Consultation Response from: KC Environmental Health (Pollution & Noise Control)
2024/92855 St Patricks Centre, 2 Trinity Street, Huddersfield, HD1 4DA
Change of use from mixed use community hall, dance studio and residential flat to place of worship (F1) with associated alterations, refurbishment works and retention of residential flat (C3) (within a Conservation Area)
Responding Date:
25th October 2024

Responding Ref:
WK202432666

Drawing: **PROPOSED PLANS SH1 01 (WITH DEMO).**

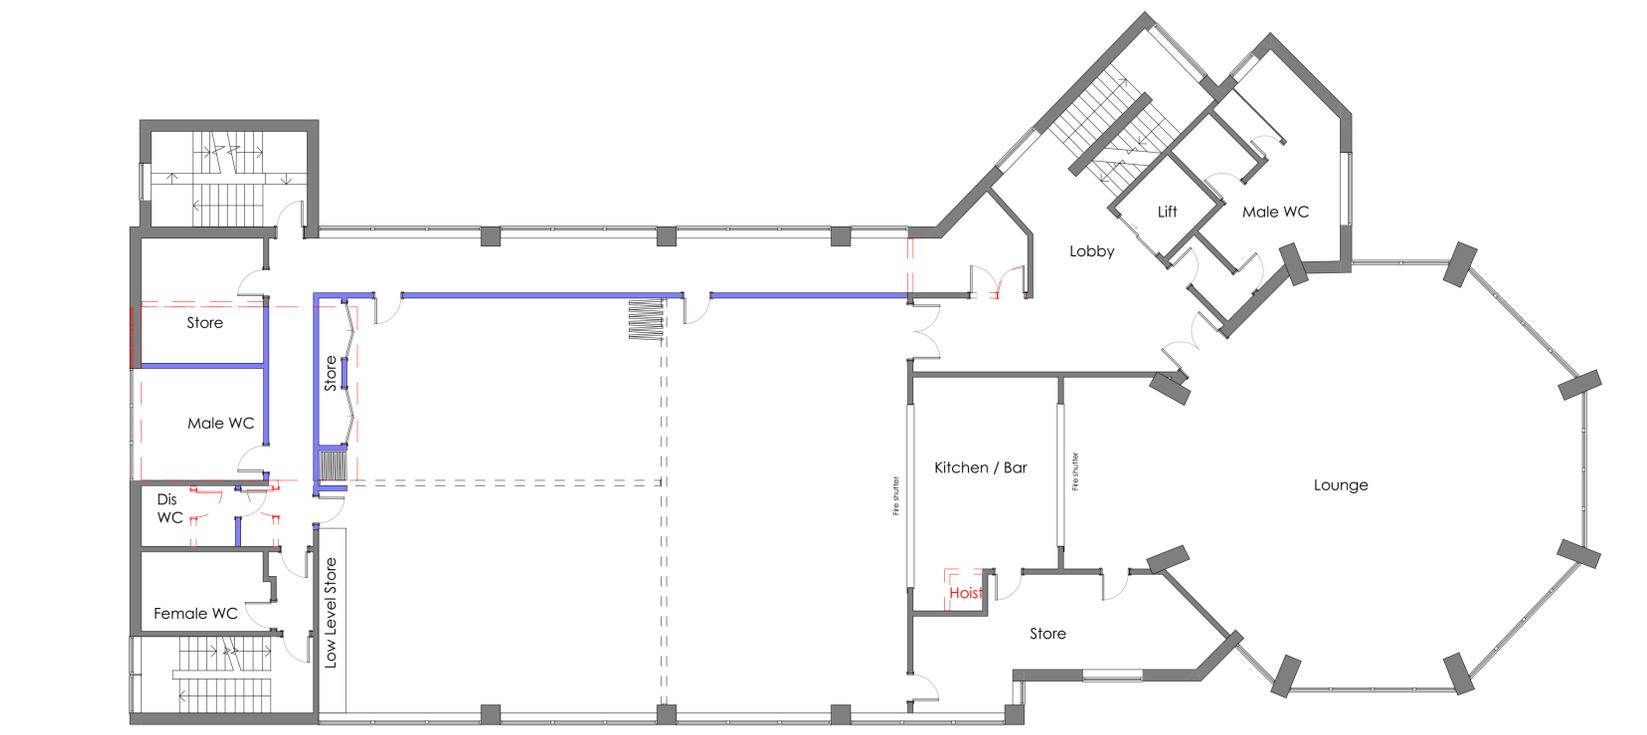
From the plans submitted it would appear a small kitchen is proposed. It is recommended that prior to development commencing the applicant should contact the Food Safety Team of Environmental Services to arrange an advice visit to discuss food safety and hygiene requirements including an appropriate layout. The Food Safety team can be contacted on 01484 22100 (ask for food safety) or by email at food.safety@kirklees.gov.uk.
